Sea Link Energy Cable

**Appendix A8 for Natural England's combined response to the Deadline 7 documents
and to the All Interested Parties – Invitation to Comment
Natural England's Advice on Suffolk Onshore Ecology**

Planning Inspectorate Reference EN020026

21st October 2026

Plate 3.1 Hedgerow connecting Important Hedgerows 3 and 5 outlined in blue

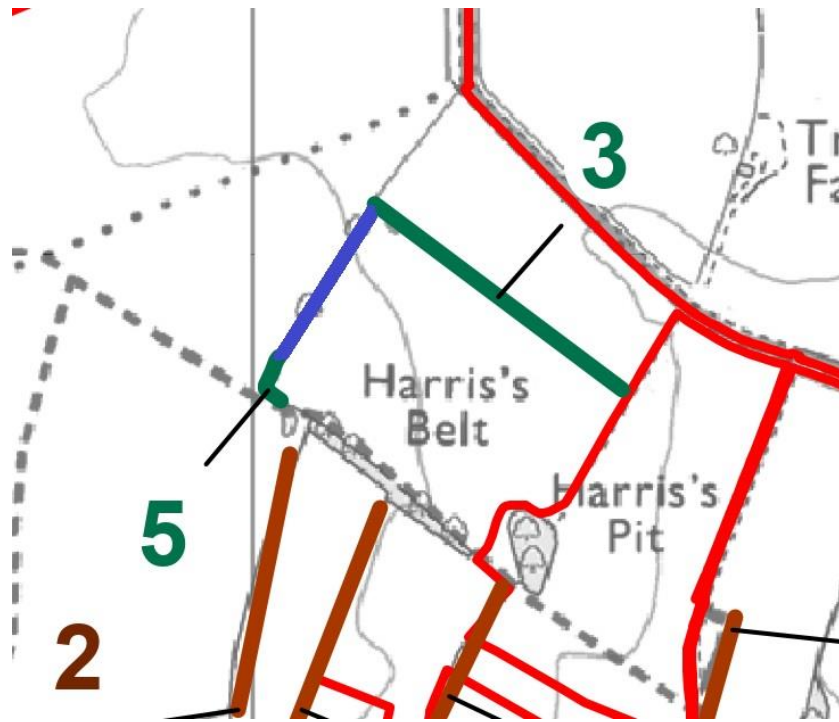
2	A3	The applicant references commitment B30 stating there will be a minimum setback of 20m of construction compounds from the hedge used by barbastelle. Natural England advises that it is not necessarily the distance between the commuting hedge and the construction compound that is relevant, but the level of hedge illumination from the compound. Please see comments above.	Impacts of indirect lighting need to be considered, following guidance within GN08 that suggests illuminance at or below 0.2 lux in the horizontal plane and 0.4 lux in the vertical plane as appropriate limits.
3	A3	Natural England requests that the need for permanent operational lighting is appropriately justified, given the likely negative impact of the permanent Converter Station operational lighting to bats. As discussed above, the main issue is the resulting lux level of surrounding light spill, combined with the level of bat importance of the illuminated habitat.	Justification should be provided for the need for permanent overhead lighting. The impact of this should also be considered in line with above comments.

conditions should be followed for all features of importance to bats, regardless of whether the illumination is direct or indirect
4	B30	B30 states that ' <i>A minimum 20 m setback of construction compounds from the hedge used by barbastelle which connects Important Hedgerows 3 and 5 as shown in Application Document 6.4.2.2.A.7 Suffolk Important Hedgerows will be instituted.</i> ' Natural England advises that it is not necessarily the distance between the commuting hedge and the construction compound that is relevant, but the level of hedge illumination from the compound. Please see comments above.	As above.
